Ribble Valley
Borough Council

My reference: 3/2019/1094

Ribble Valley Borough Council, as local planning authority, hereby confirm that their prior approval is **REFUSED** under paragraph (2A) of the above legislation for the proposed development at the address shown below, as described by the description shown below, and in accordance with the information that the developer provided to the local planning authority:

Single storey extension to rear 6m long, 3.7m high (max) 2.85m to eaves.

PROPOSED EXTENSION

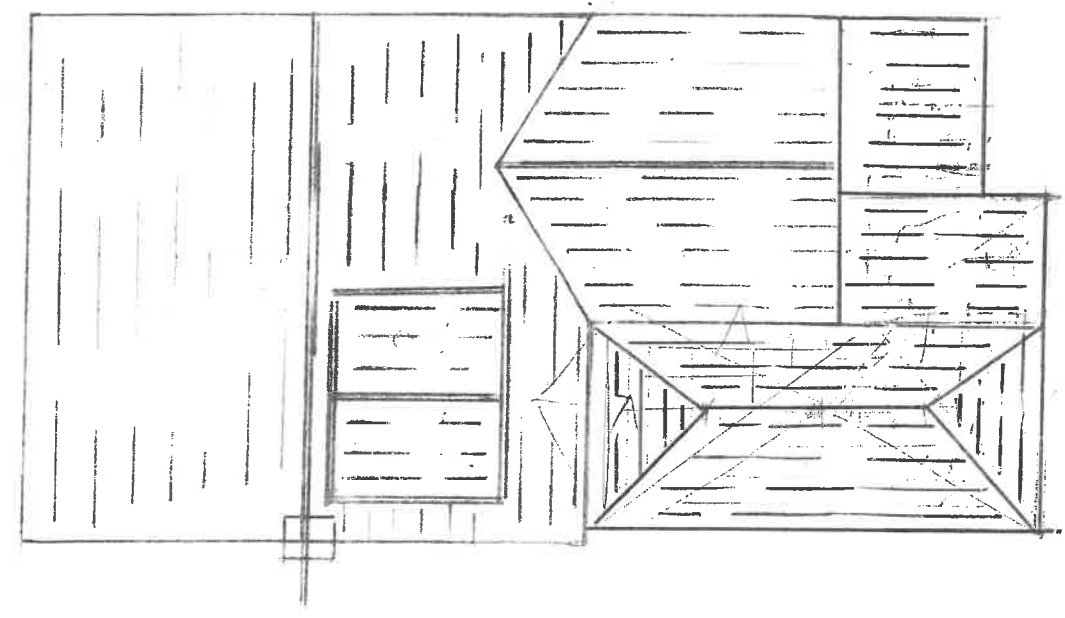
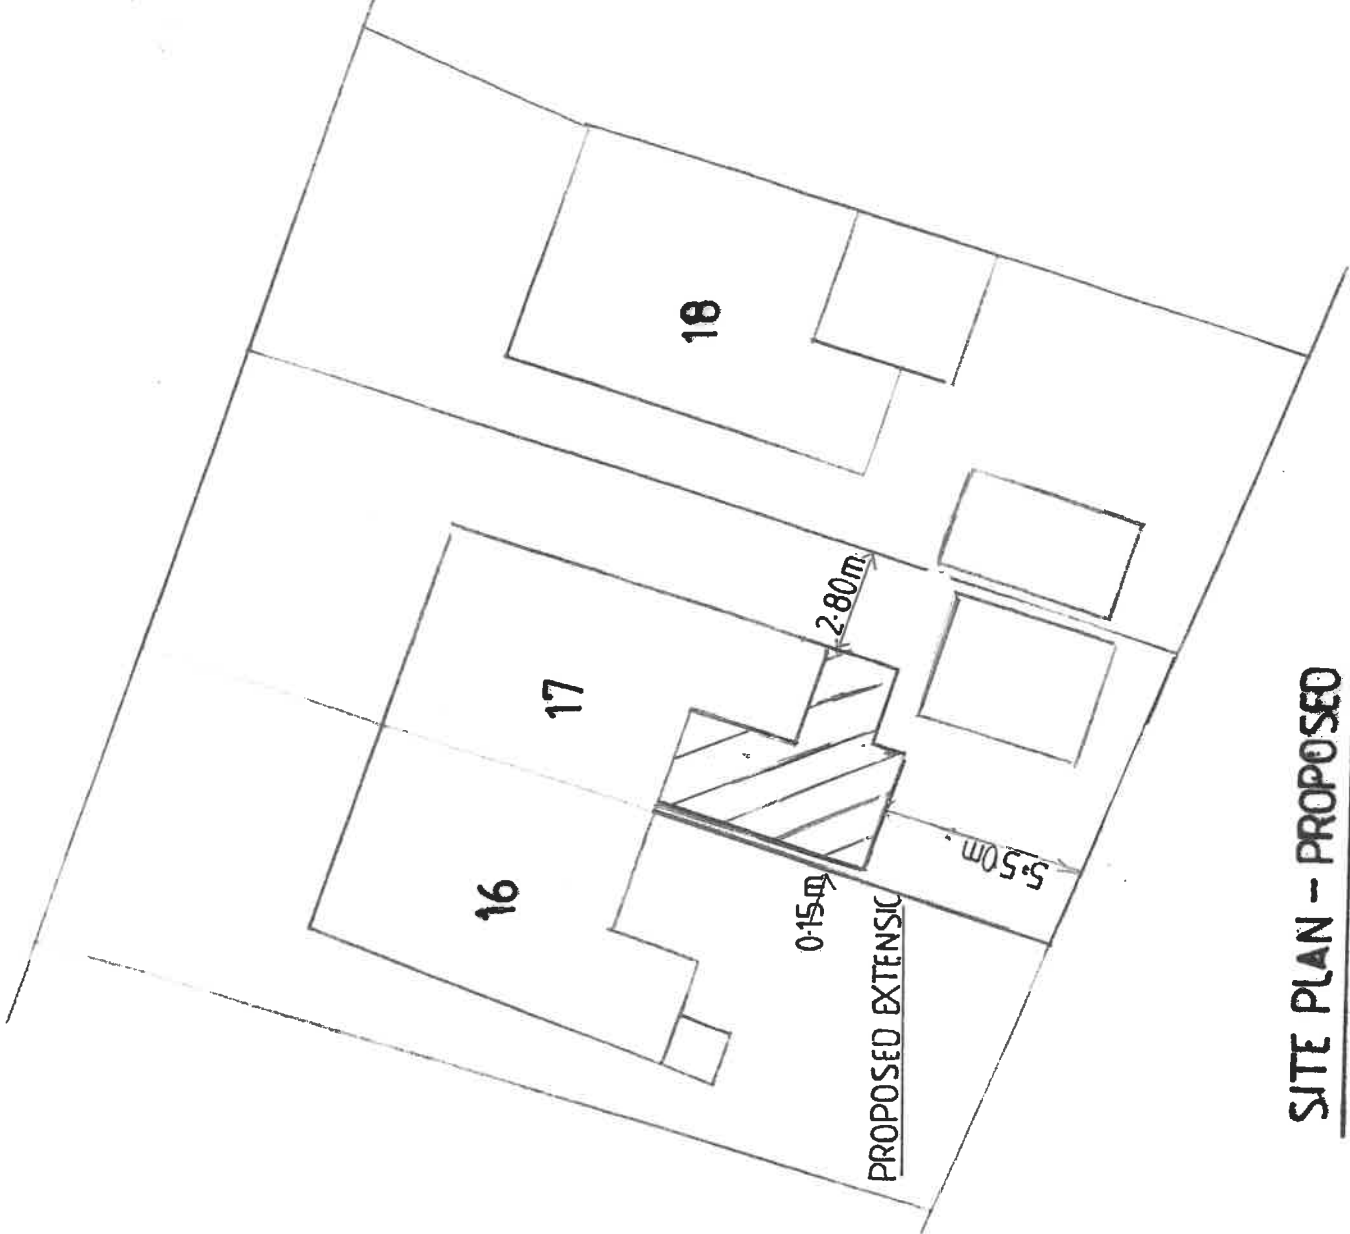
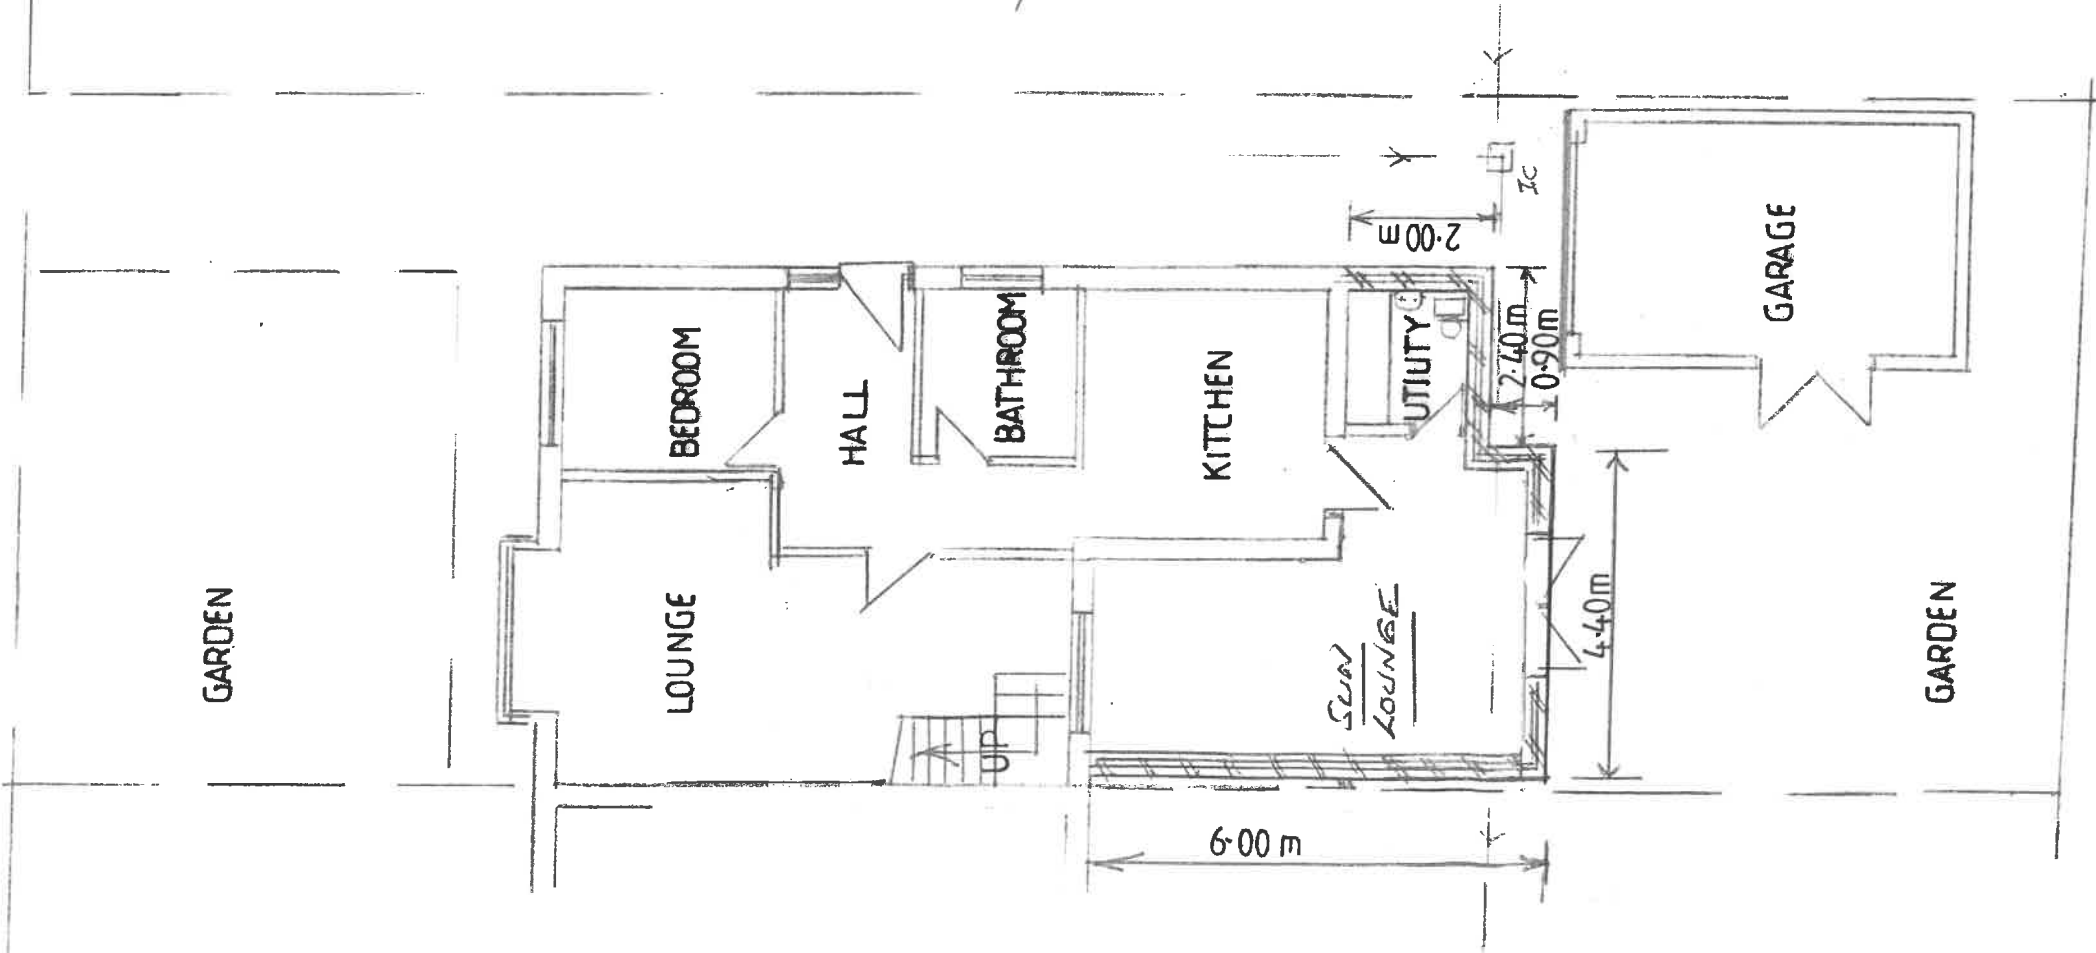
This written notice indicates that the proposed development cannot be determined by the proposed larger home extension prior approval procedure. The proposed development fails to meet the requirements of paragraph A.1(j) of Schedule 2 Part 1 Class A as it would extend beyond the side wall of the original part (part-width) rear projection (i.e. the side wall facing the infill area) and would have a width greater than half the width of the original dwelling house.
